Thank you for your comments regarding drainage aspects for the 70 unit scheme.
Please find below a link to the latest set of documents for your review.

Condition 8

INFILTRATION BLANKET (GEOCELLULAR UNITS - CRATES - CONSTRUCTION)

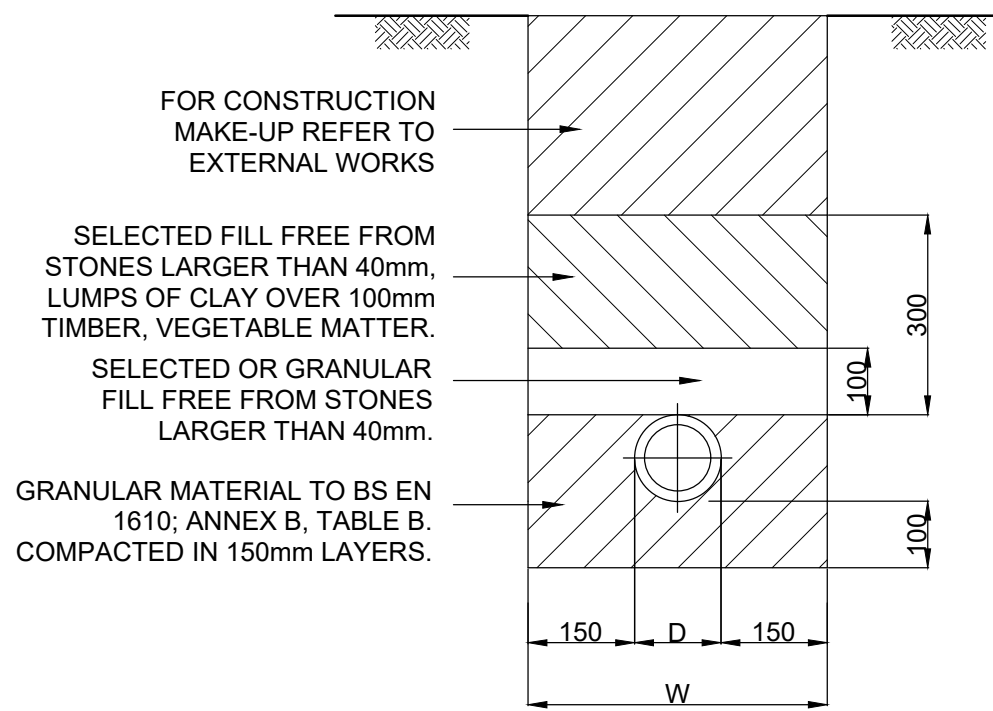
1. Please confirm distances from infiltration devices to site boundary. Our minimum requirement is 2.5m. We have indicated 2.5m offset from the site boundary and ensured that infiltration blankets are not closer to the boundary than this.
2. Can infiltration blanket 6 be moved to be solely within one rear garden rather than straddling two? Soakaway serves Plot 113-114 and so would expect this to straddle both gardens to reflect their joint ownership. There is no sufficient space between proposed houses and car ports to fit meaningful soakaway entirely within a single garden
3. Pipes 3.006 and 3.005 appear to be modelled as swales rather than pipes. Please update. Pipes 3.006 and 3.005 were modelled as pipes not swales (please see below snapshot of submitted calculations) – Arun DC comment incorrect.

N:\19-156 - Land at Stakers Farm, Yapton\Tech\Acad\Figures\YAP-130-SK005 Swale Sections.dwg

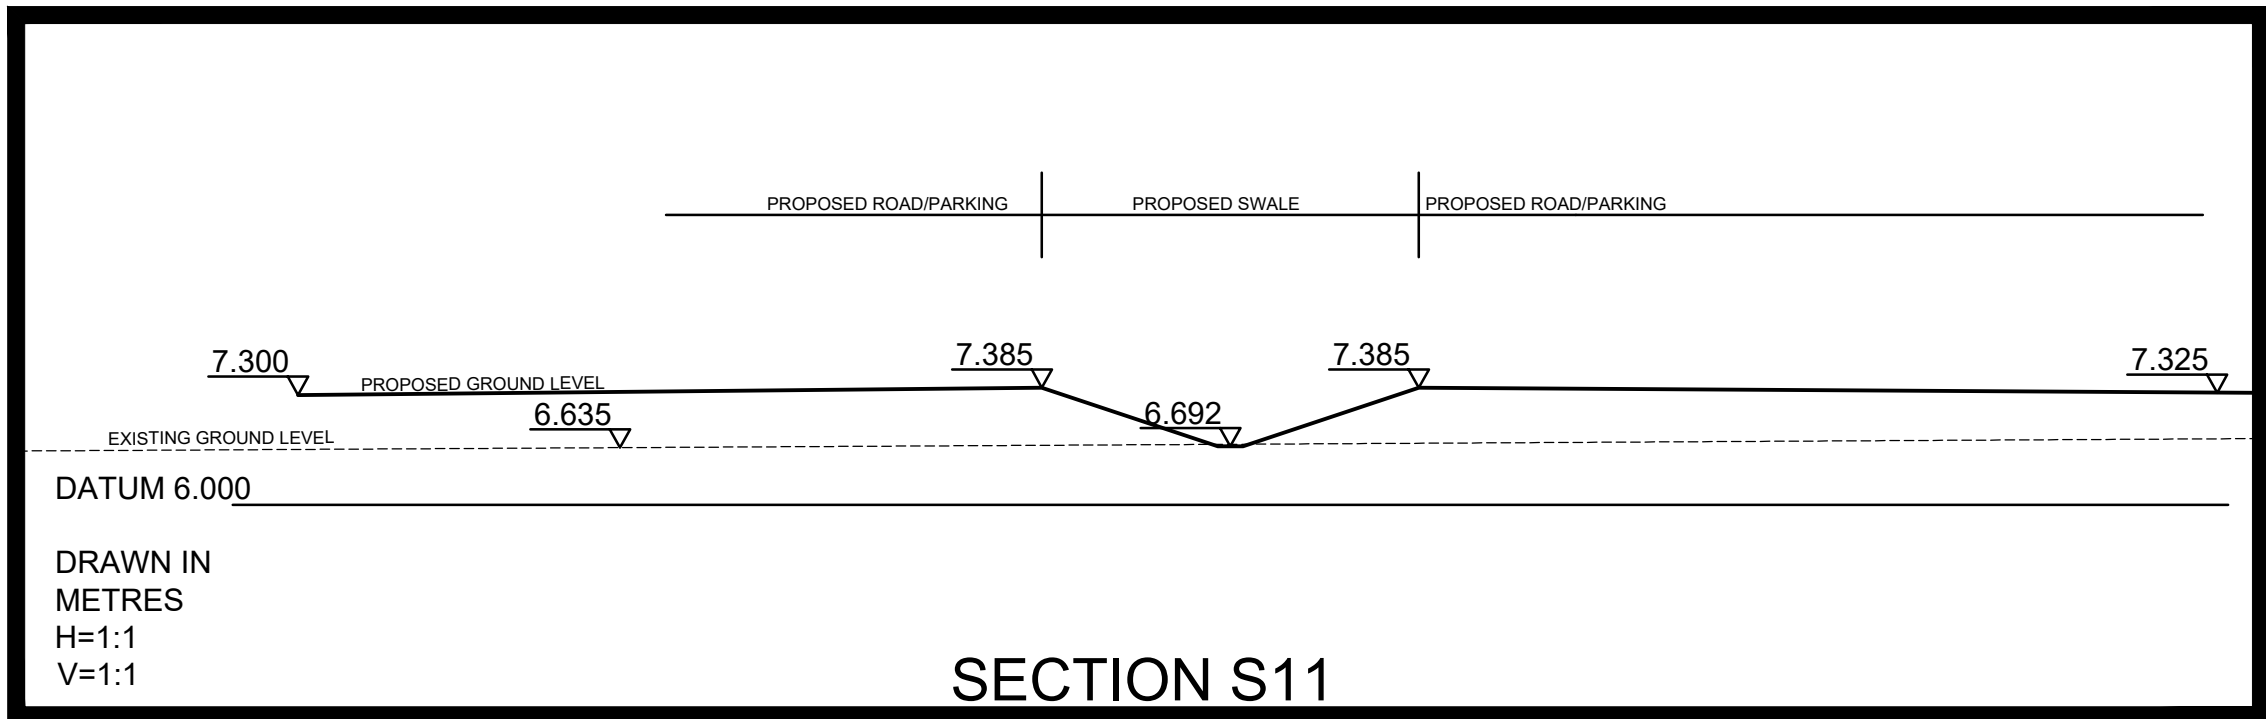
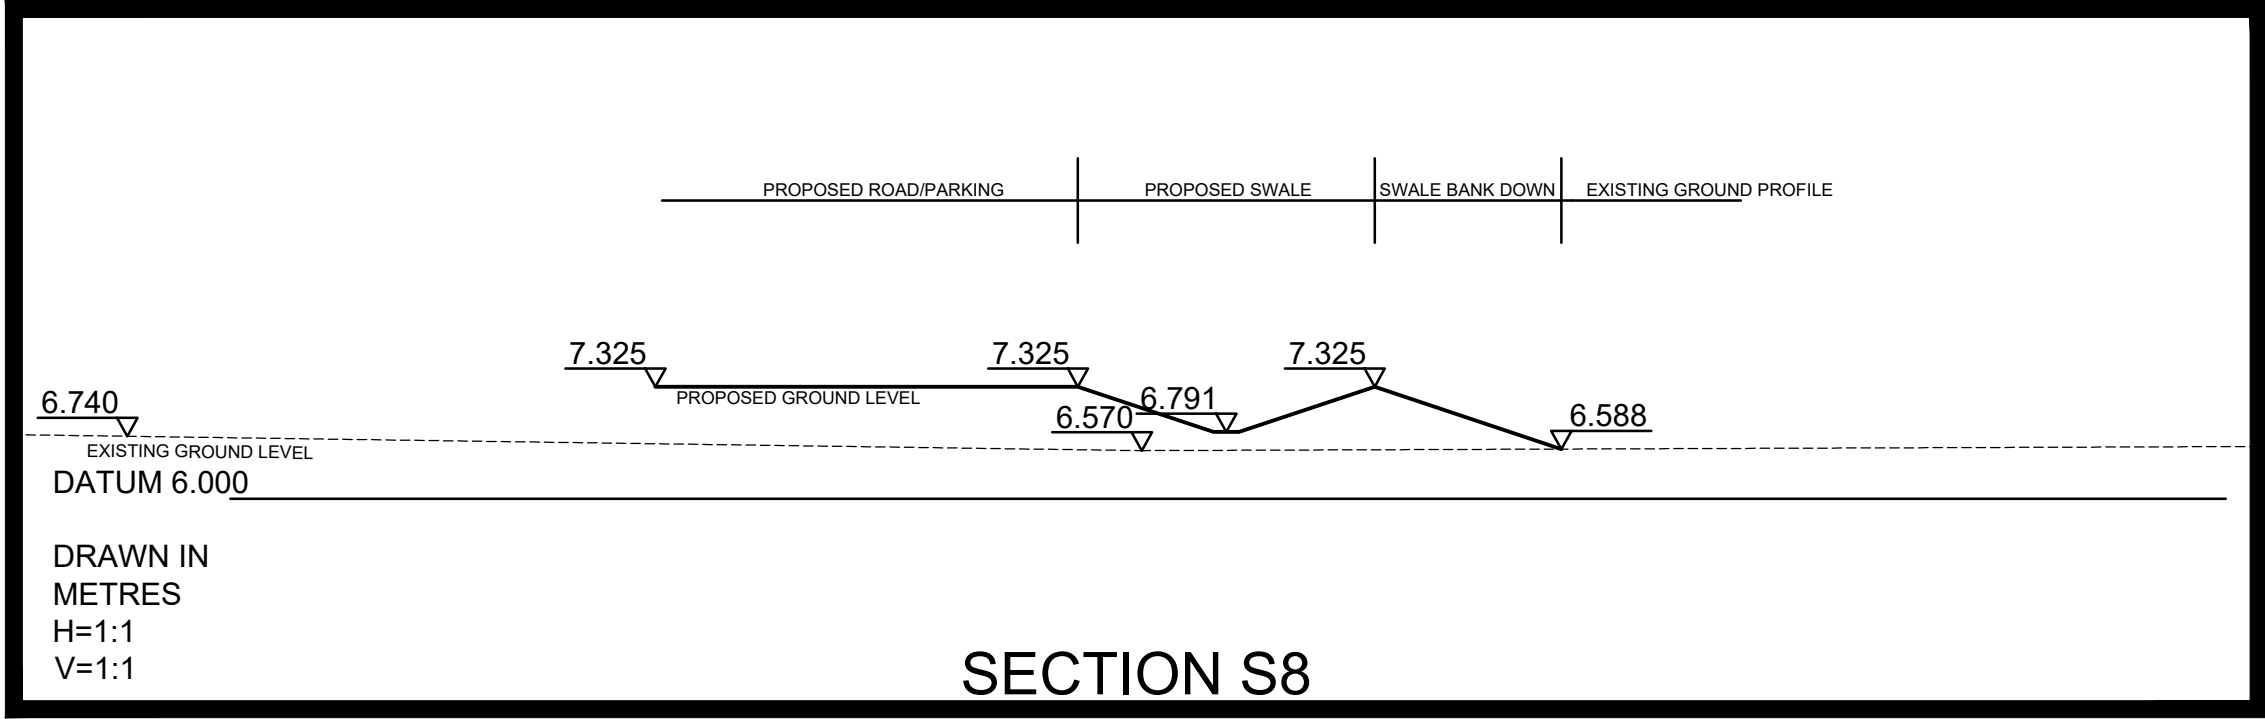
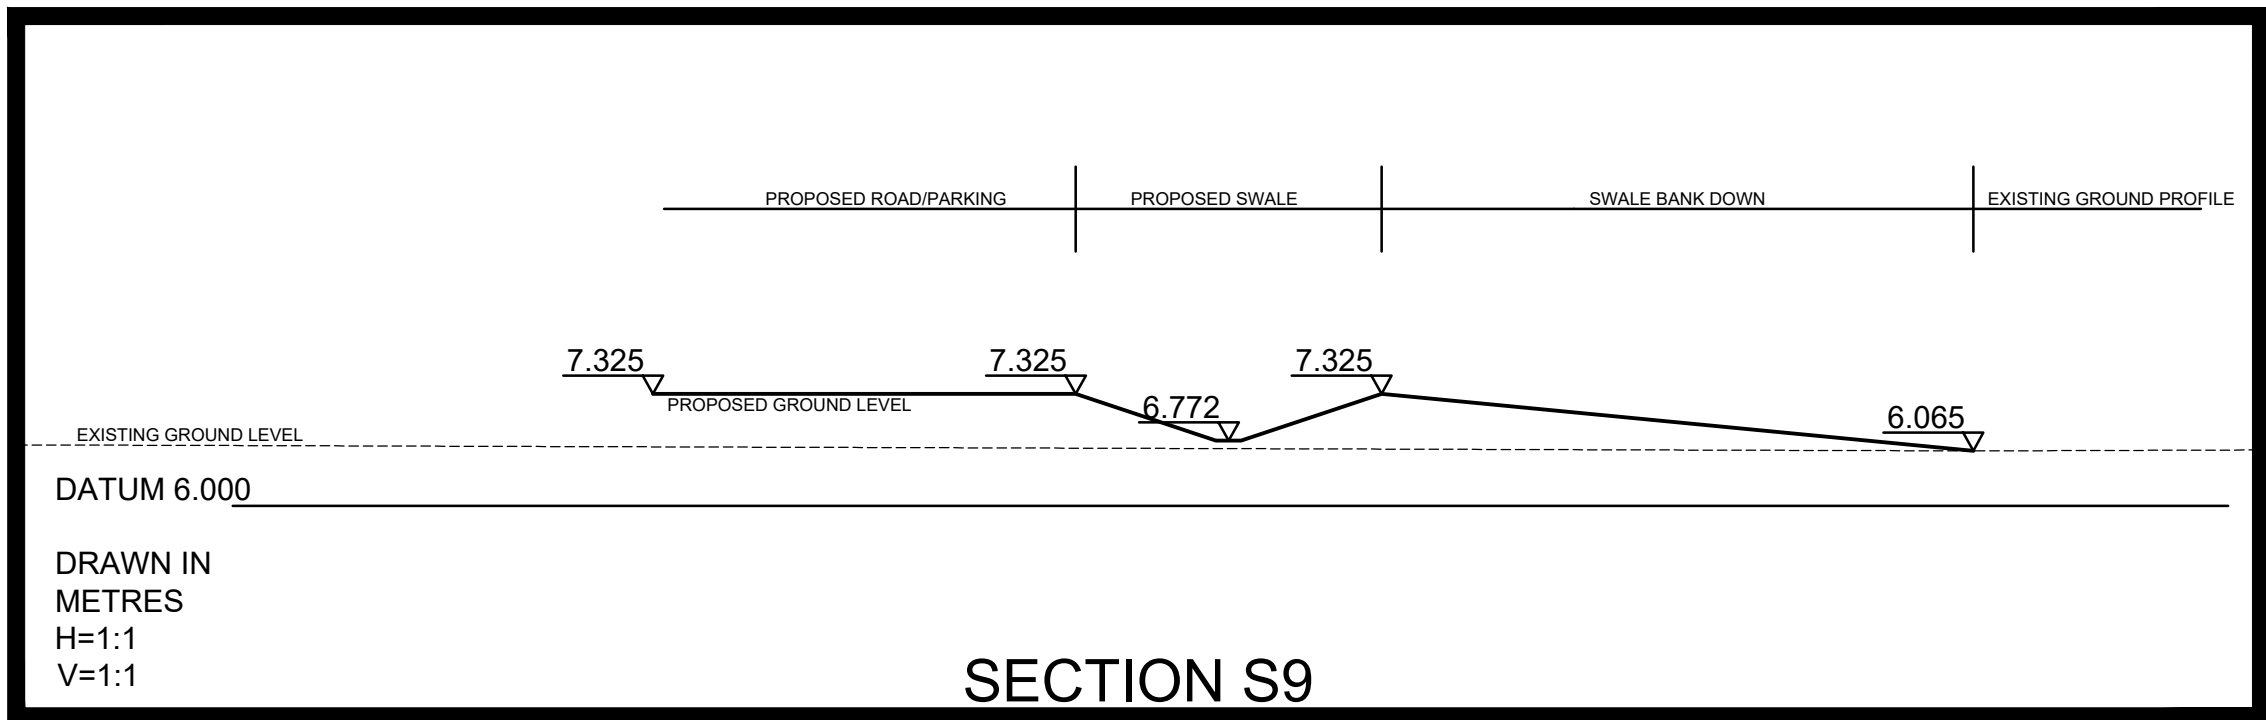
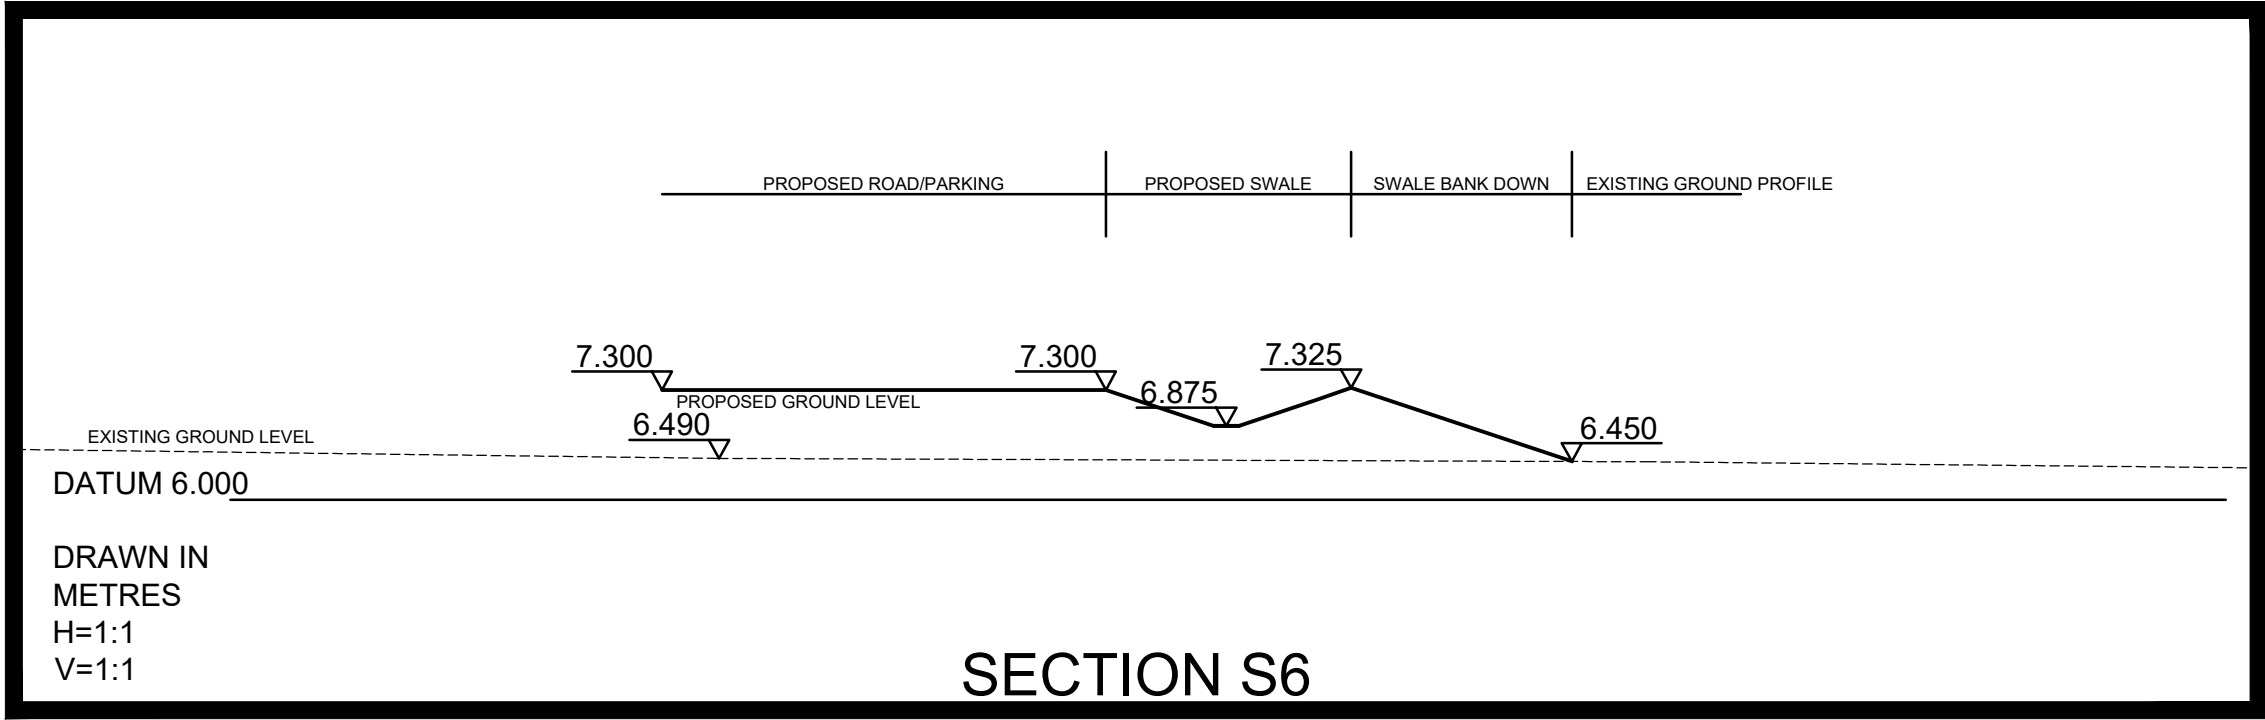
4. Please provide swale cross sections and a long section. Please refer to drawing YAP-130-SK005
5. TP4 has an infiltration rate labelled as $1.8 \times 10^{-6} \text{m/s}$, and this appears to have been used in calculations. The worst case infiltration rate at this location was $1.7 \times 10^{-6} \text{m/s}$. BRE365 test results represented on drawing were based on worst case February results, whereas Arun DC comments refer to March results – TP4 from February is not in the same location as TP4 from March. Drawing 'YAP-130-026G' was updated with March BRE365 test location and prefixes are now added to differentiate between February and March locations.
